HIGH MESA Consulting Group

RE: Letter Explaining How EPC Conditions Have Been Addressed – Project # 1011354
Request for Final Sign-Off for EPC Approved SDP for Subdivision.
Tracts C & D, Mark3S Holly Development-West

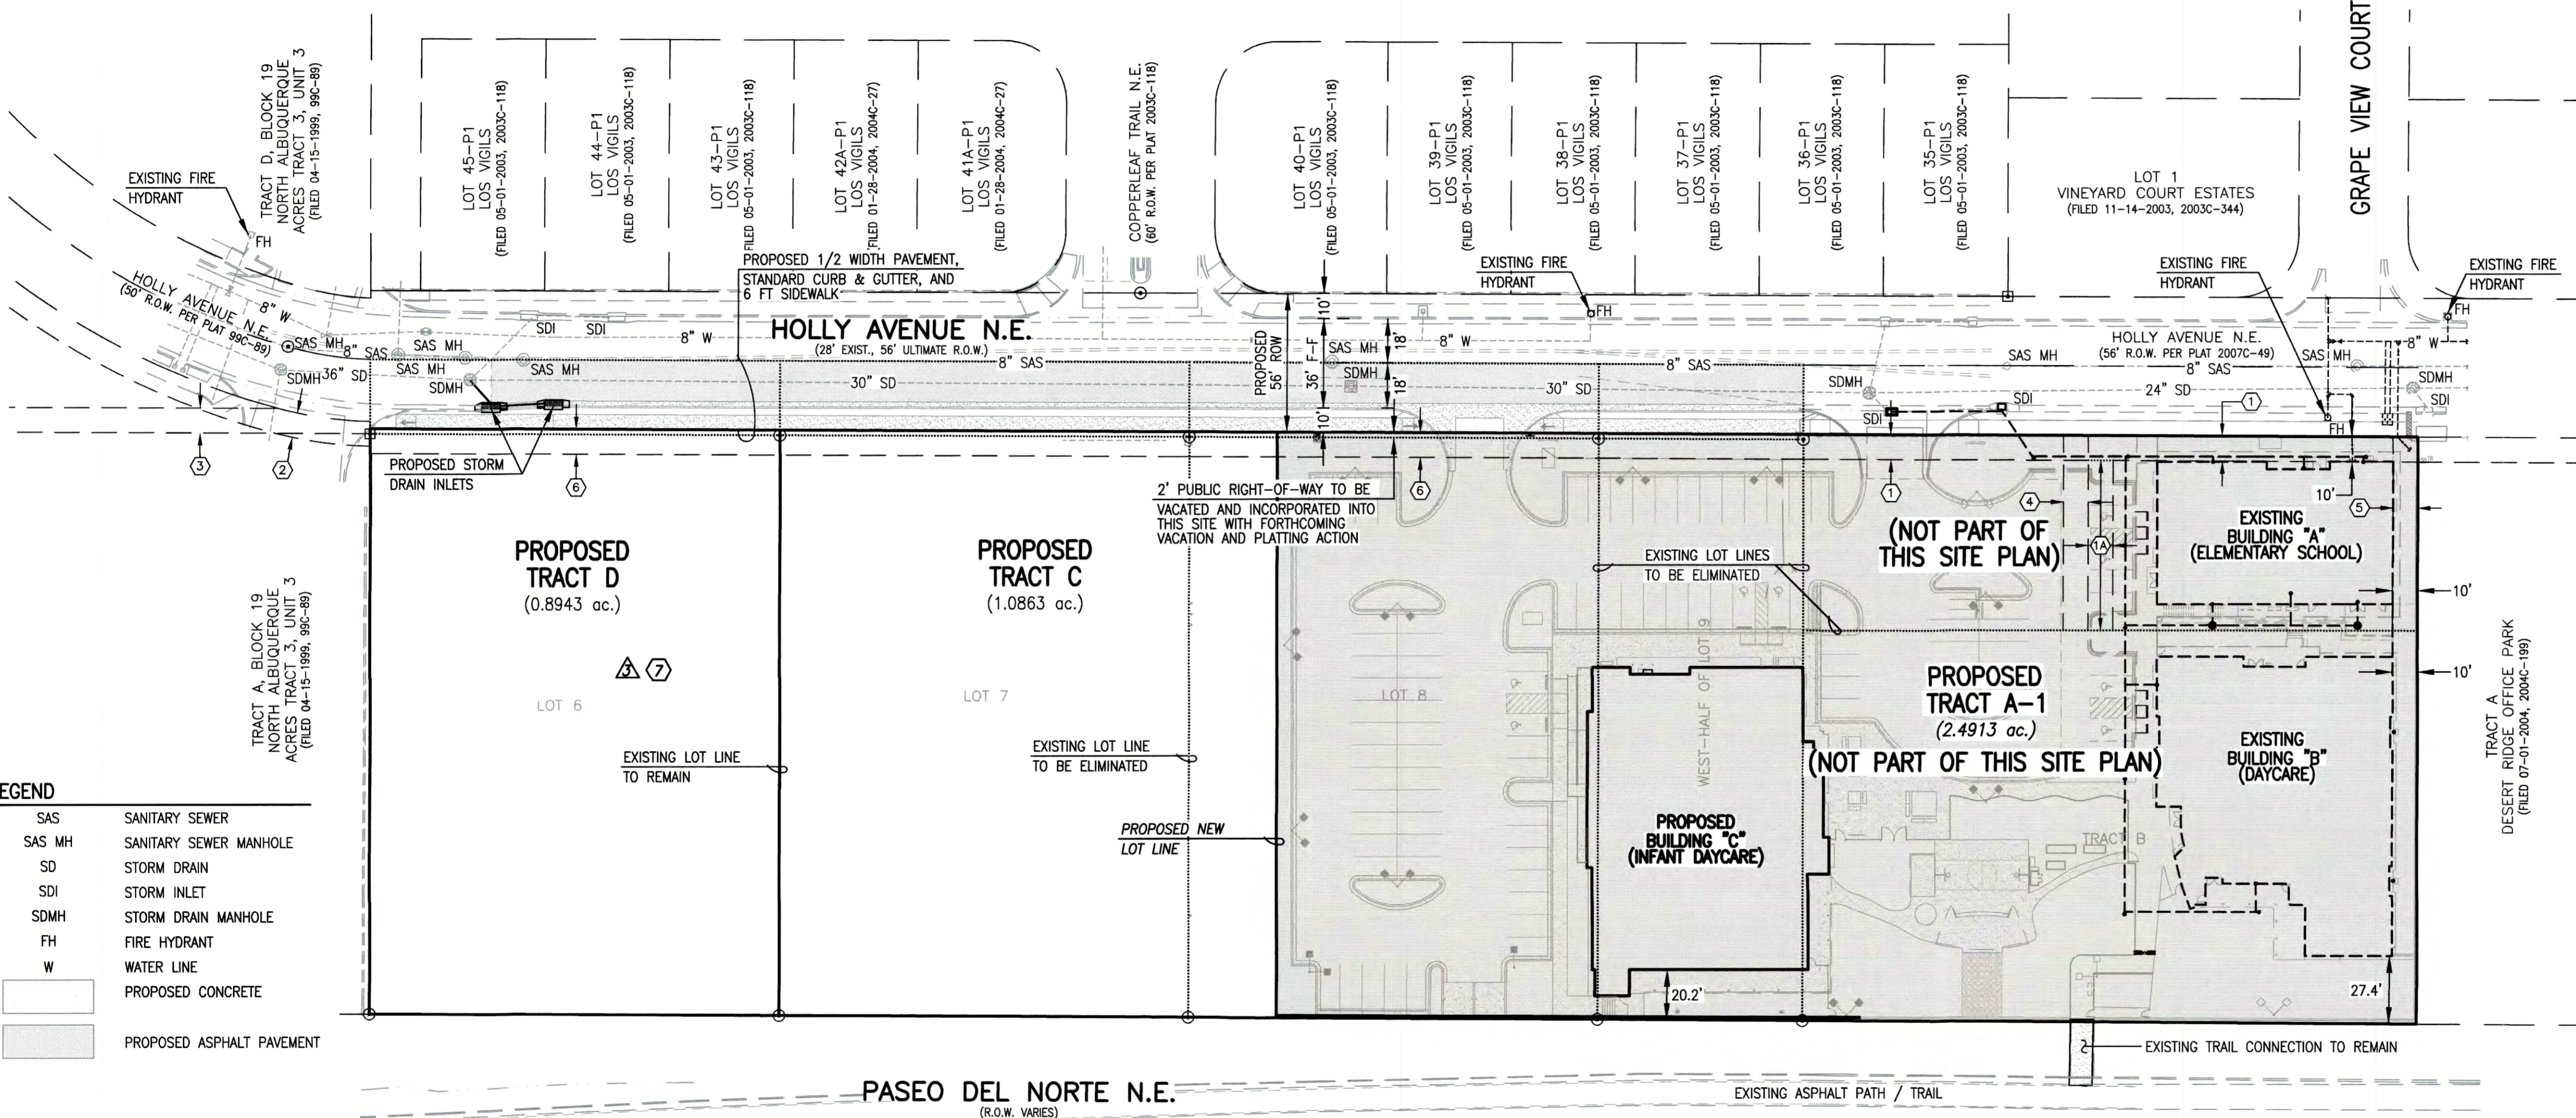
- 3) Definition of Site Development Plan for Subdivision:
 - A. Setbacks shall be pursuant to the LCSDP. *Note 8 added with reference to the LCSDP.*
 - B. Notes regarding FAR shall be clarified. - *Site Development Plan for Subdivision Notes 5-7 have been added for clarification for FAR.*

- 4) La Cueva Sector Development Plan (LCSDP):
 - A. Add a note stating that development on the lots shall return to the EPC pursuant to the LCSDP. - *Note 10 added under Site Development Plan for Subdivision notes.*

- B. Clarify Note 7. The LCSDP design standards shall apply to future development. - *Note 7 was revised to provide clarification and changed to Note 9.*

- 5) Clarification:
 - A. Label and clearly indicate the proposed lot lines. - *Proposed lot line are now clearly labeled on site plan.*
 - B. Use fade-back for “not a part” portion. - *A fade-back shading was used on “not a part” portion of plan.*

- C. Add a reference to the related project, Project# 1005237/17EPC-40033 and 17EPC-400034. - *Reference was added to Sheet 1 in Site Development Plan for Subdivision Notes.*
